Application for removal or variation of a condition following grant of planning permission. Town and Country Planning Act 1990. Planning (Listed Buildings and Conservation Areas) Act 1990

Condition 18 to be varied to allow a revised layout which alters the Care Homes main entrance position

Variation to Condition 18 - to allow the following approved plans to be varied;

Drawing Title: Proposed Elevations 1 of 2

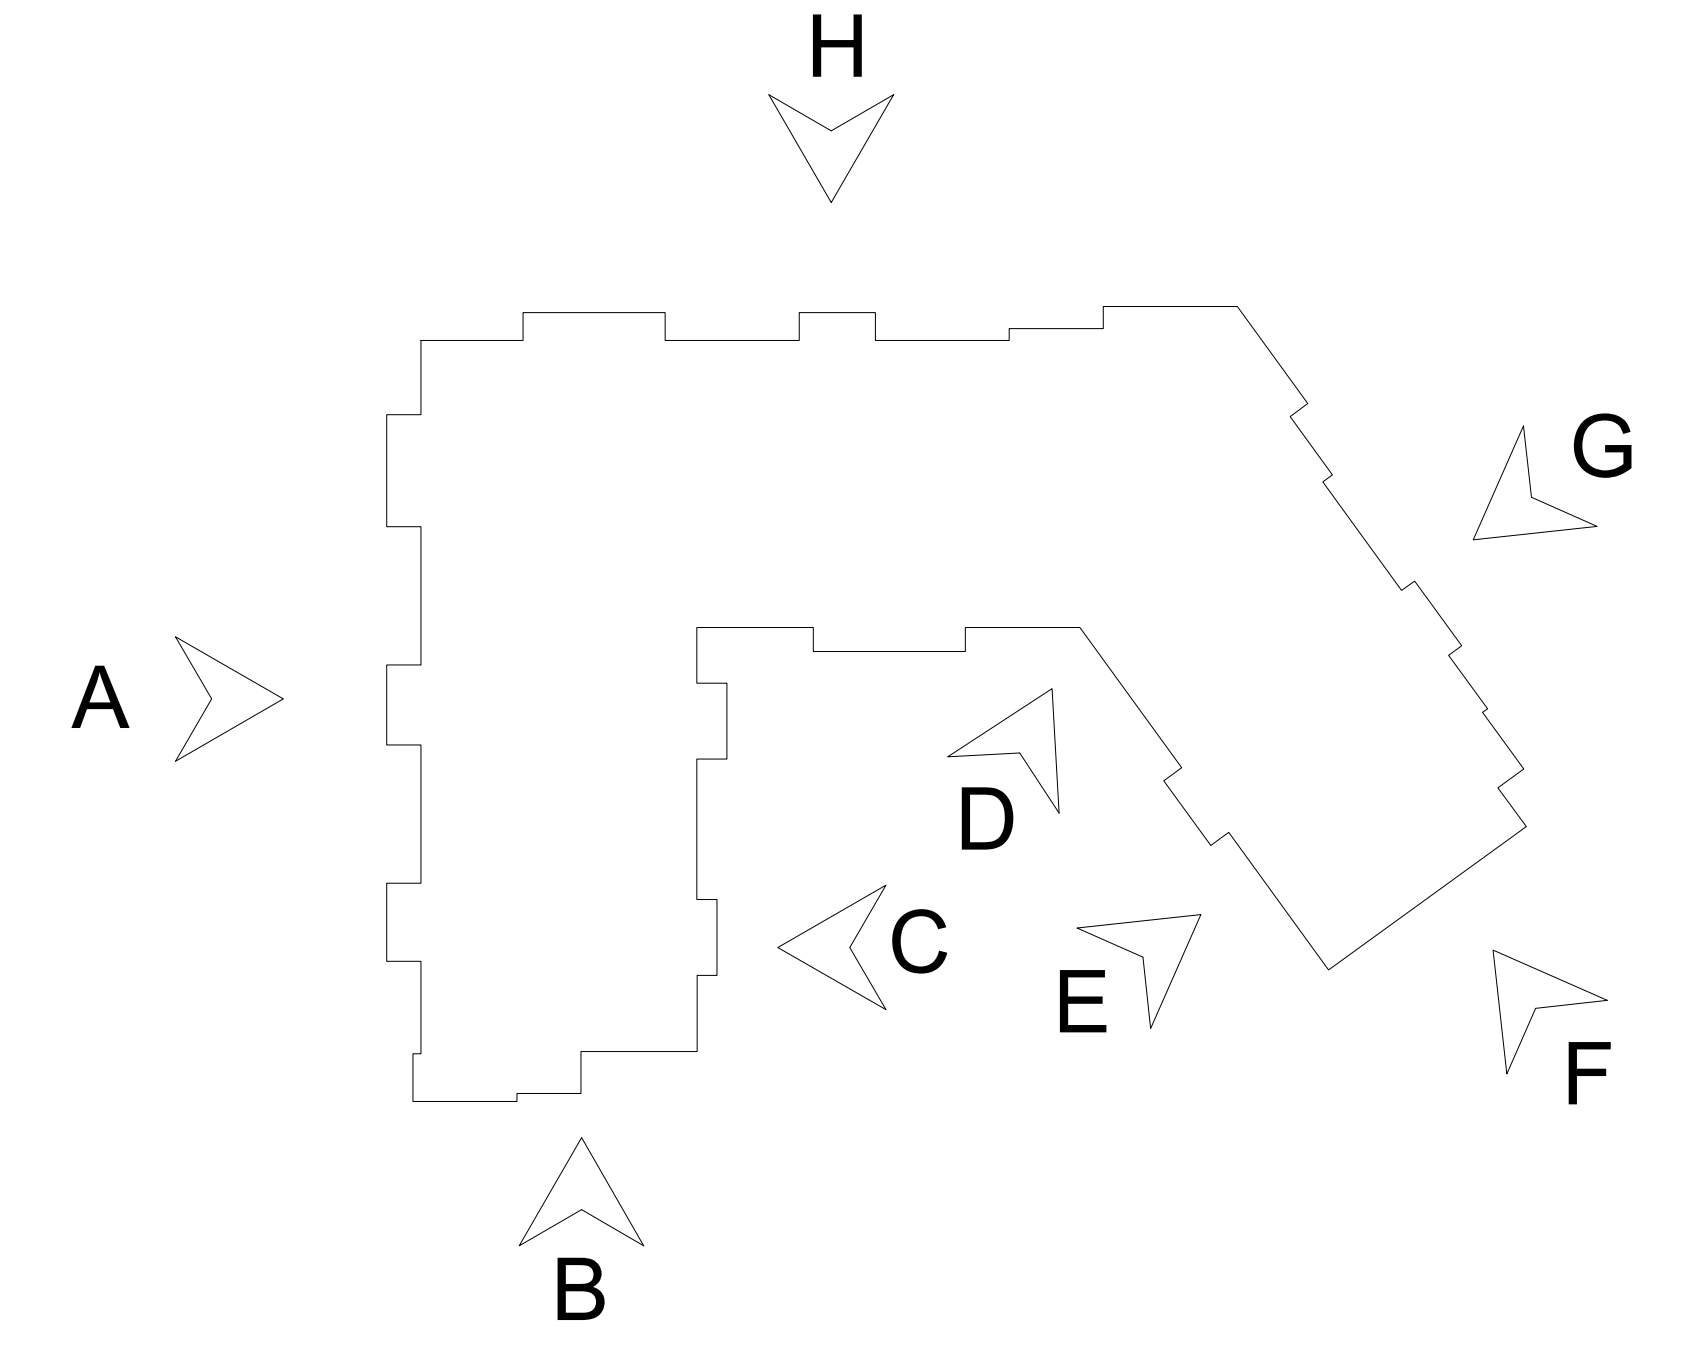
In addition, the alterations will pick up Ground Floor Bedroom windows to be changed to external doors/windows. This will allow residents to have improved access to the secure landscaped gardens while improving the natural light within the internal spaces.

(21-1 RevB 16Nov18) to be varied to (21-1 RevH Proposed Elevations 1 of 2 21Sept21)
(21-2 RevB 16Nov18) to be varied to (21-2 RevH Proposed Elevations 2 of 2 21Sept21)

Drawing Title:
 Proposed Elevations 2 of 2

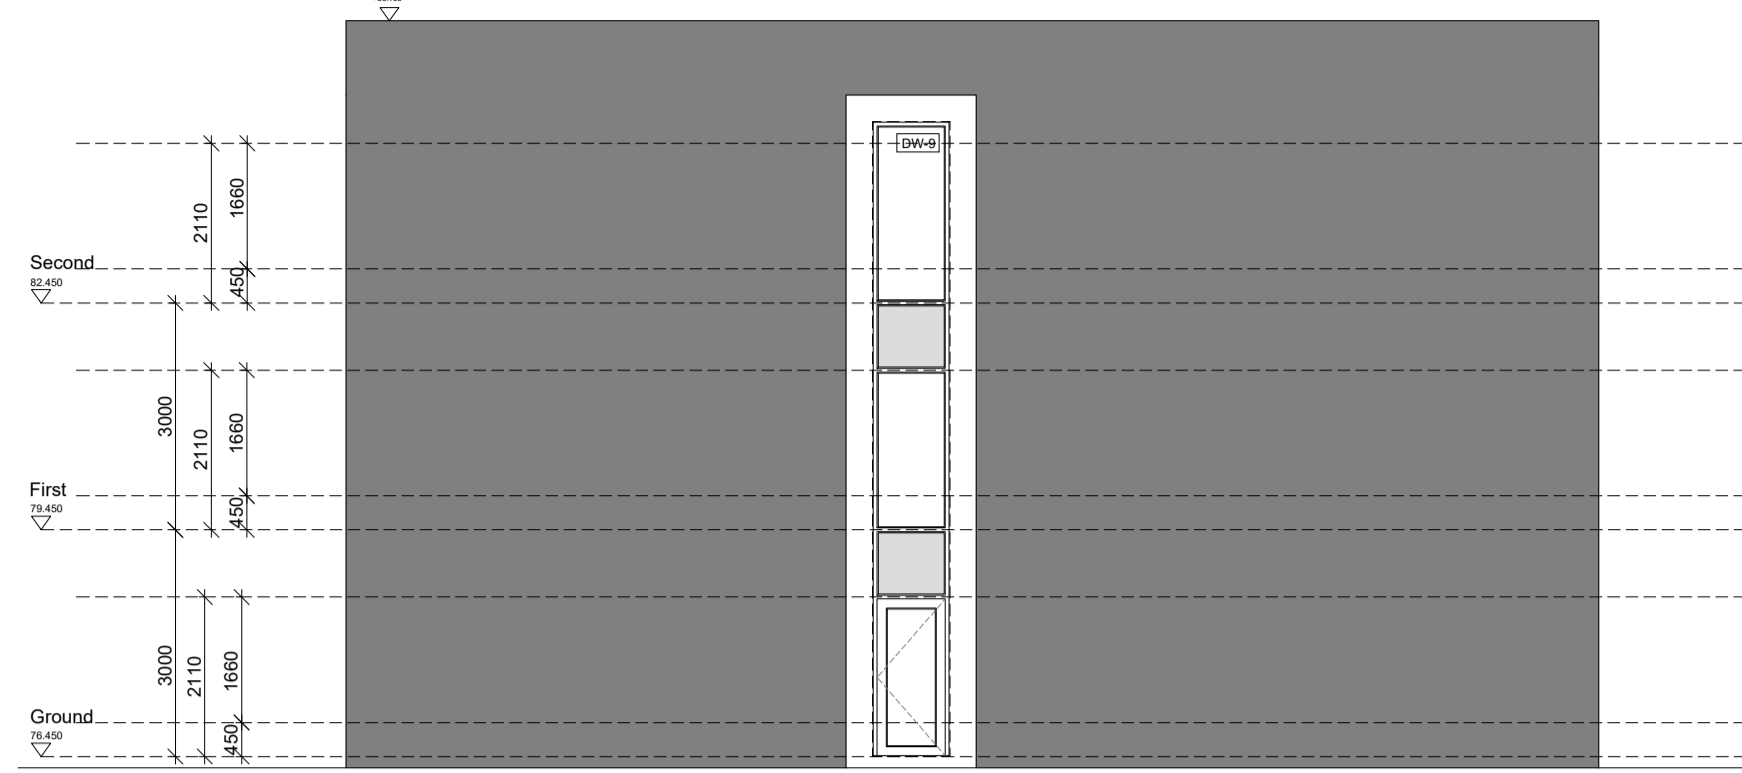
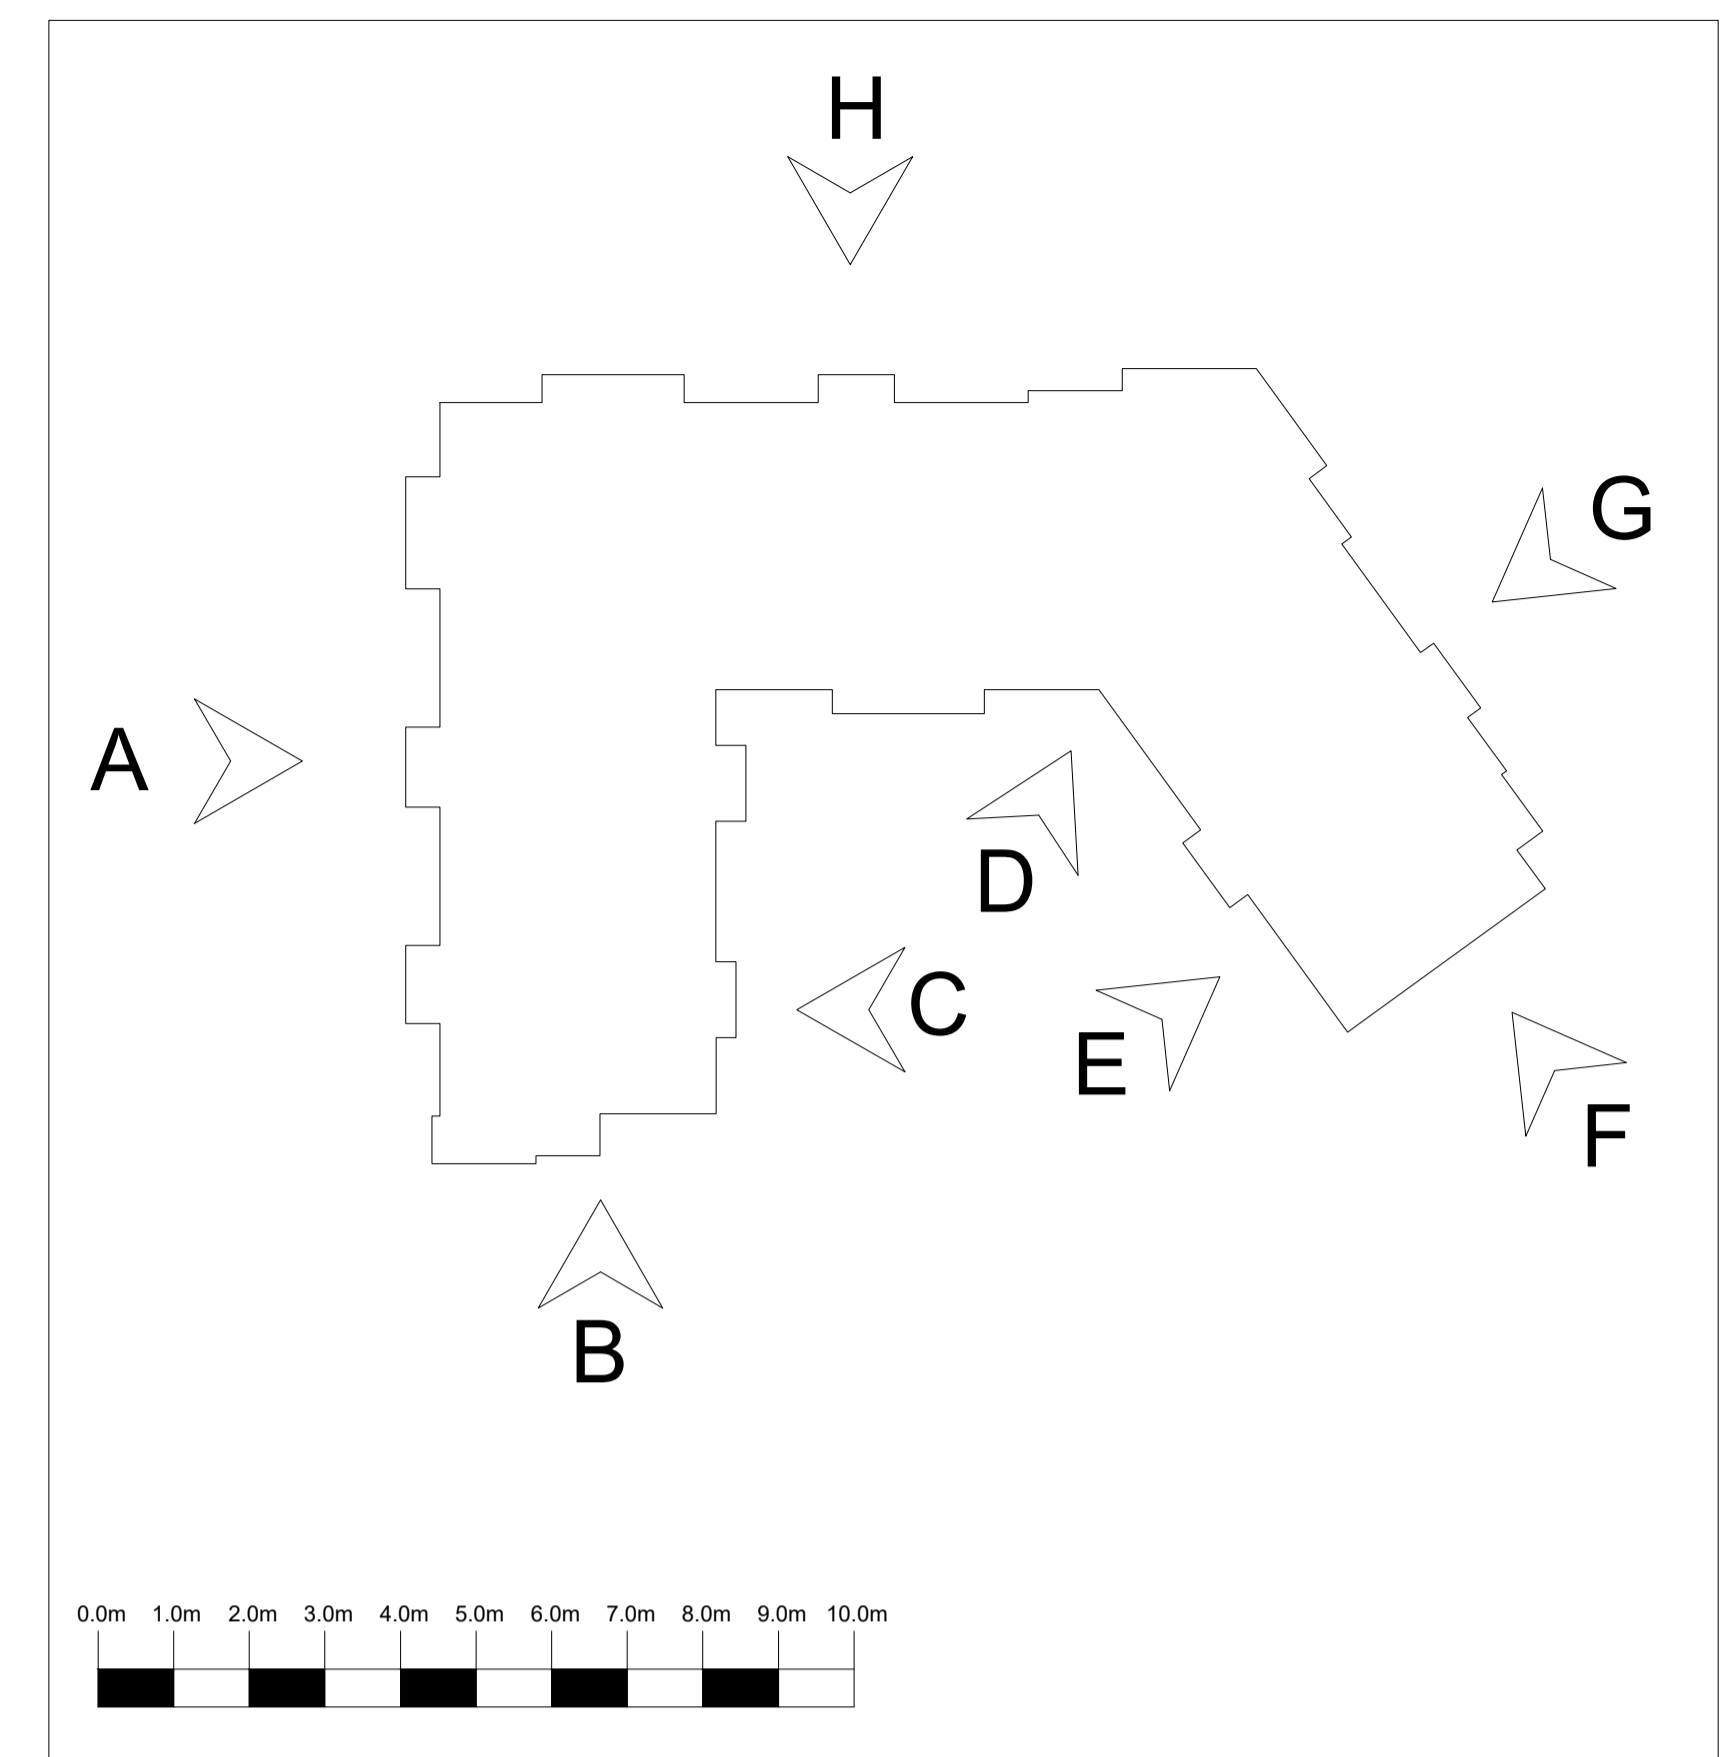
In addition and following internal alterations, the two rear balconies to the northern side of the site have been omitted. These balconies previously served residential bedrooms however following the changes these would serve back of house staff areas which would not be used.
